**Major Projects
Council Submission
Project Mars Data Centre (SSD-82052708) (Lane Cove)**

Environmental Impact Statement Response for the Project Mars Data Centre at 12 Mars Road, Lane Cove West.

DRAWING TITLE
**GENERAL ARRANGEMENT - ROOF
 PLAN**

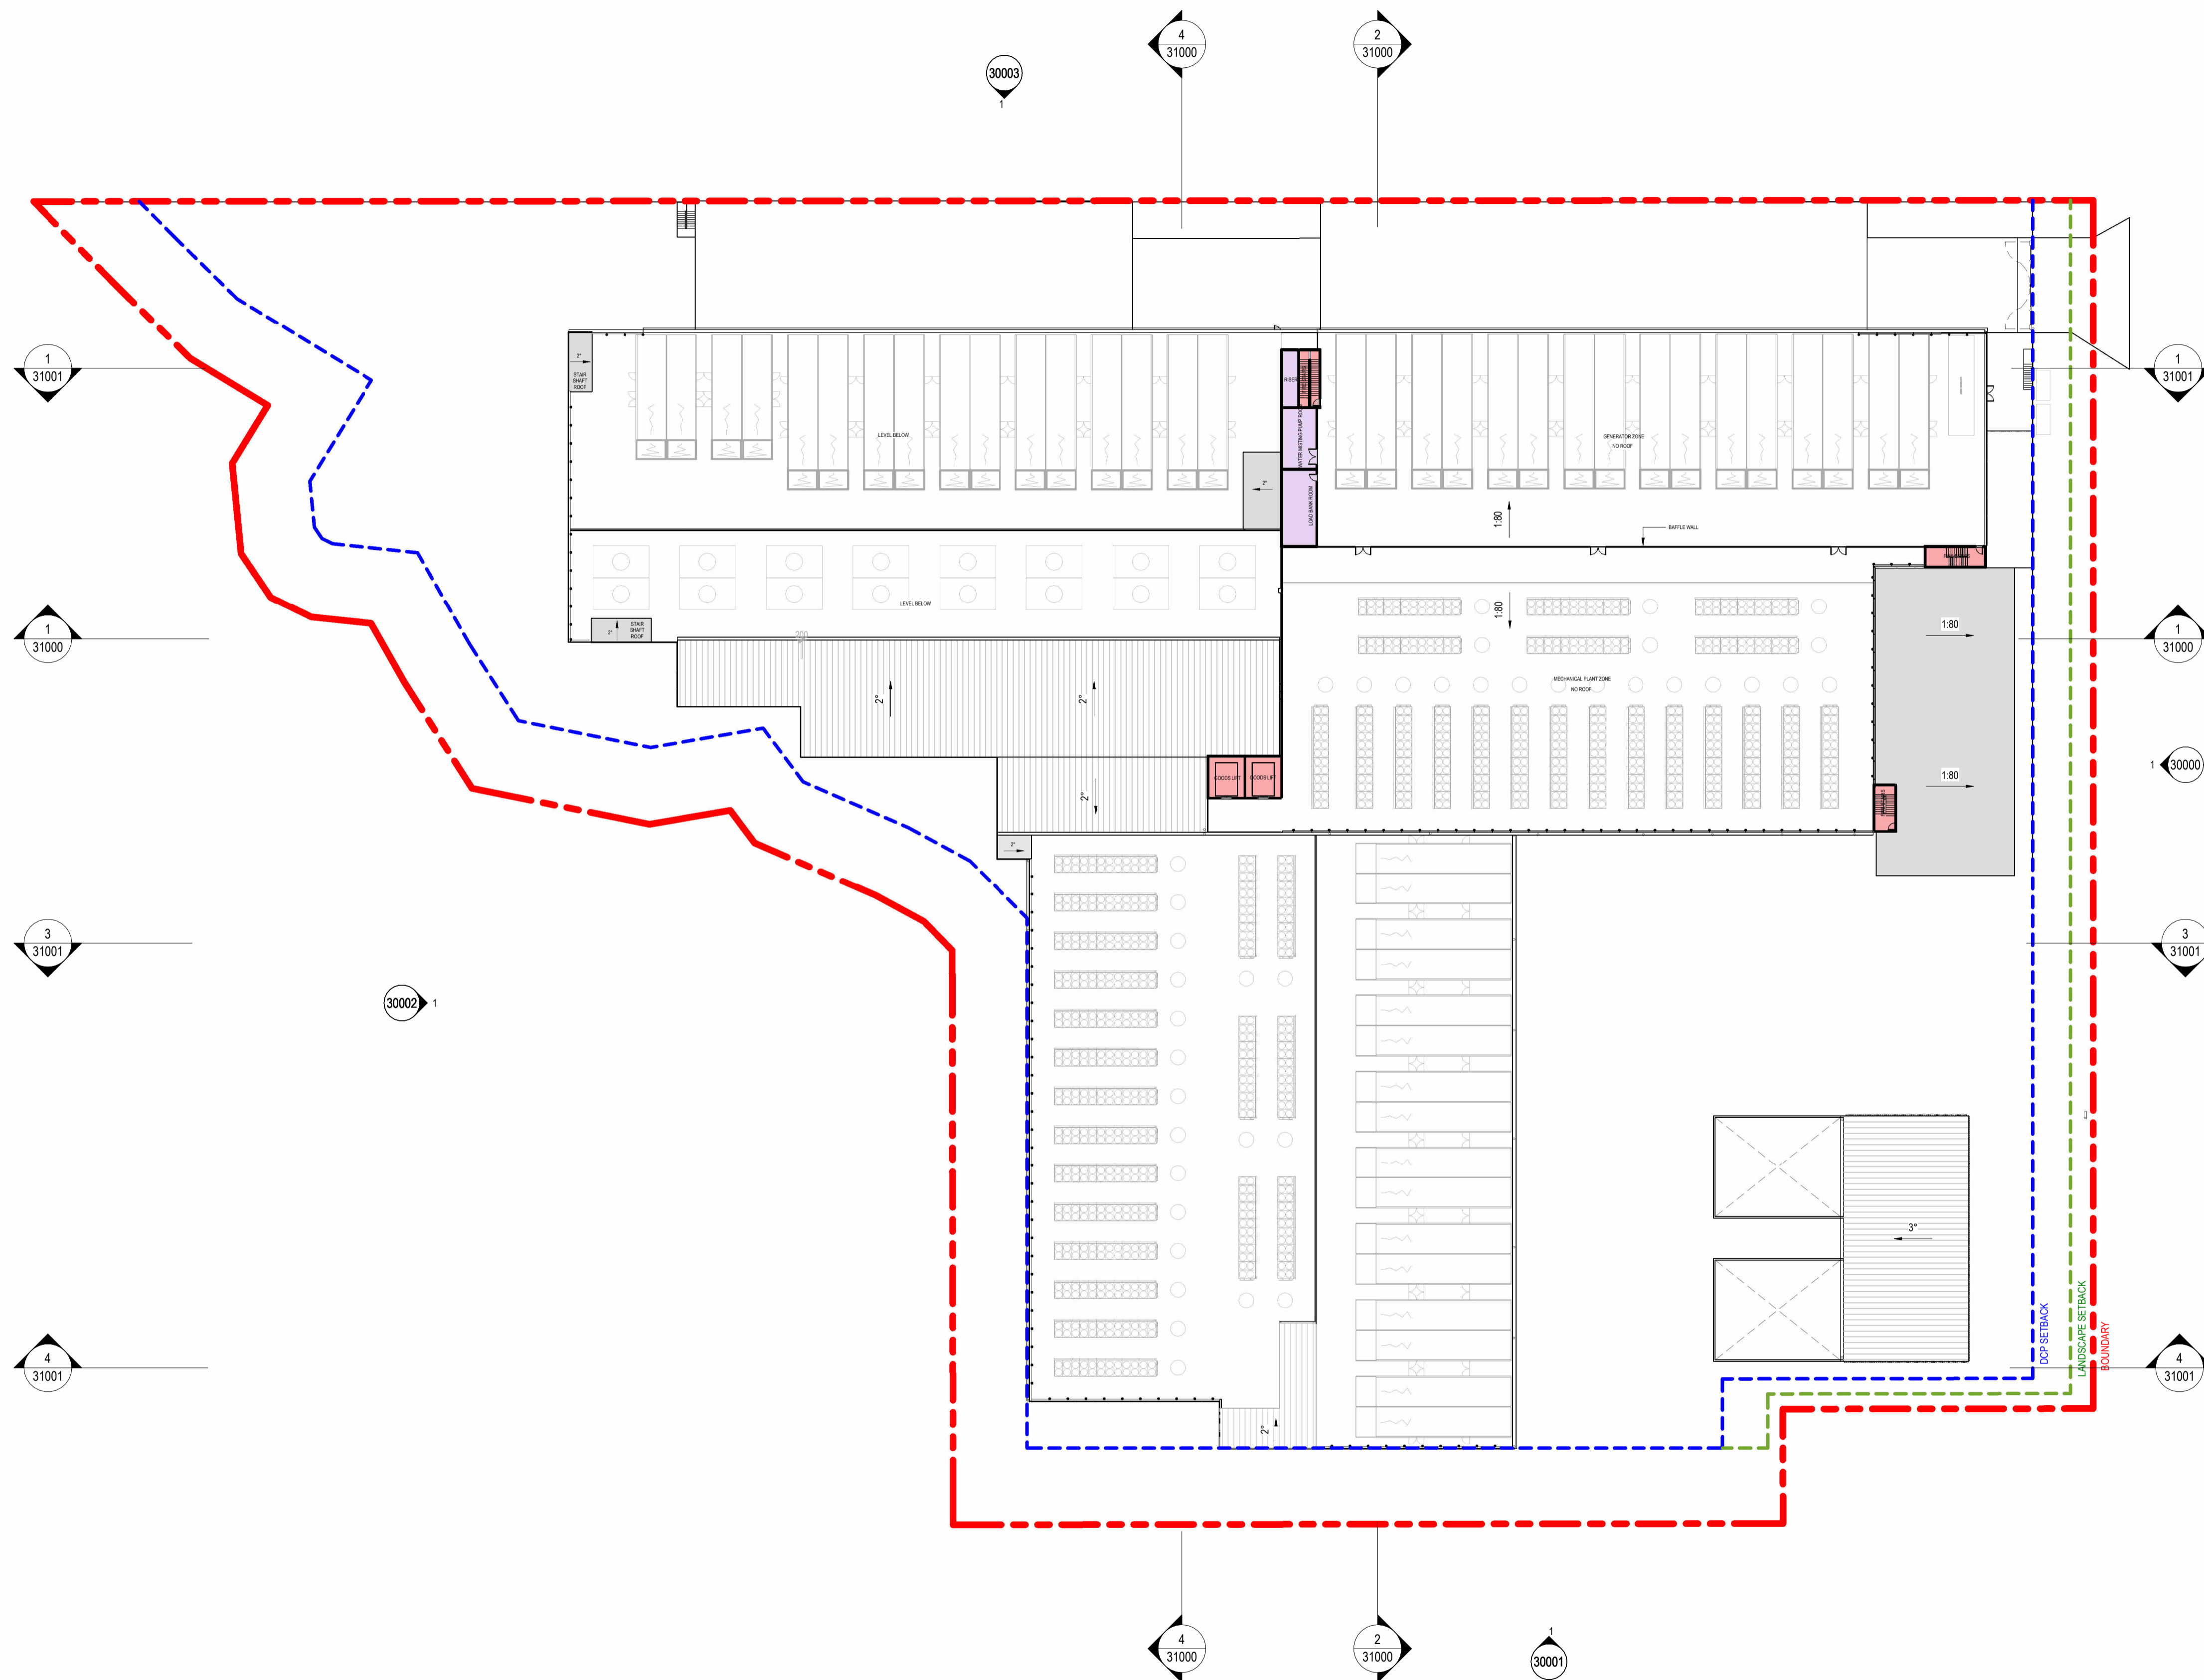
The proposed development includes a height which significantly breaches the maximum permissible height standard, as shown in **Figure 2** below. A Clause 4.6 request to breach this development standard has been provided and is not supported by Council. The proposed development fails to satisfy the relevant tests required for assessing the proposed breach as outlined below.

A predominate portion of the proposed development roof area exceeds the height development standard. This does not present a development which is constructed in accordance with the site's topography, as illustrated in **Figure 2** below. These impacts are exacerbated due to the level of excavation (up to 8m) proposed to accommodate data halls and service areas well below existing ground level, refer to excavation section later in this response. The development seeks consent to significantly alter the sites natural ground level and its relation to surrounding development. The development is not sympathetic to the sensitive residential and environmental receivers in proximity to the site.

EARTHWORKS PLAN

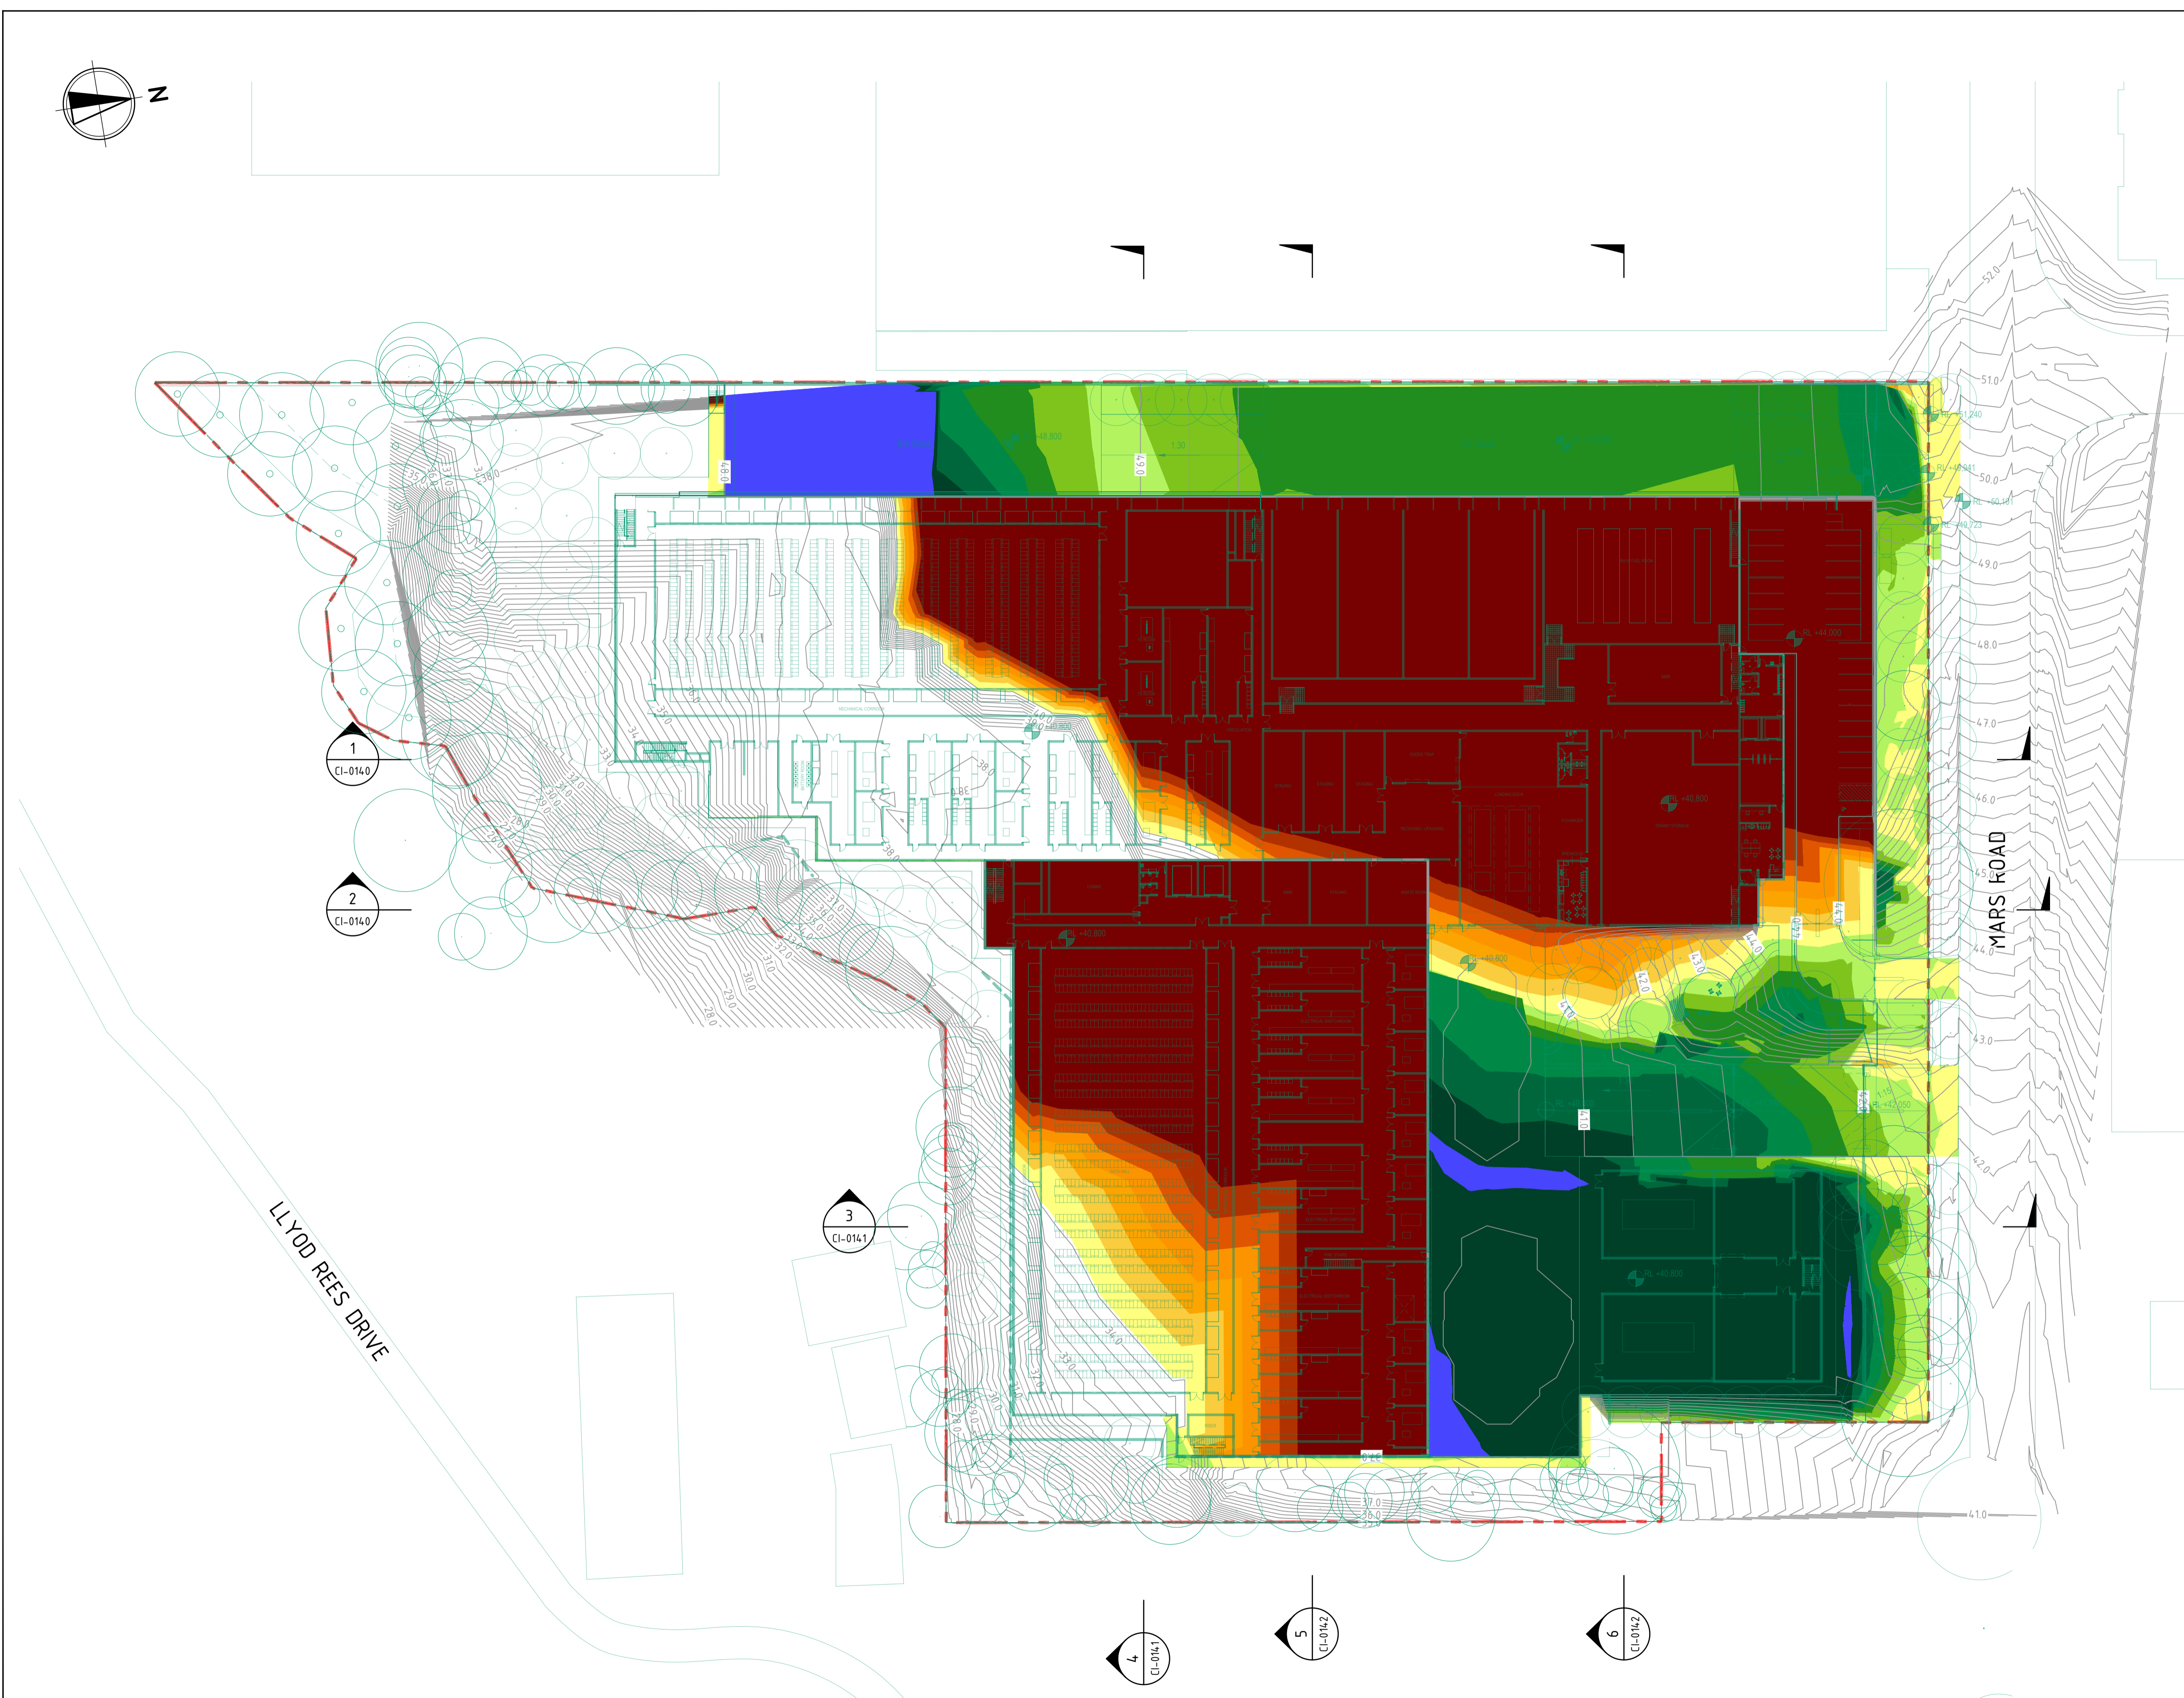
The proposed development includes excavation well beyond what is considered reasonable for the industrial zone. No developments within the industrial zone provide excavation beyond 8m. This is of particular concern where sensitive Bushland and Riparian areas are located adjoining (and naturally down slope) of the subject site, which have not been considered as discussed throughout this response. The proposed excavation is not provided in small sections to address site topography, but expands the full width of the development, as shown **Figures 24 to 27** below.
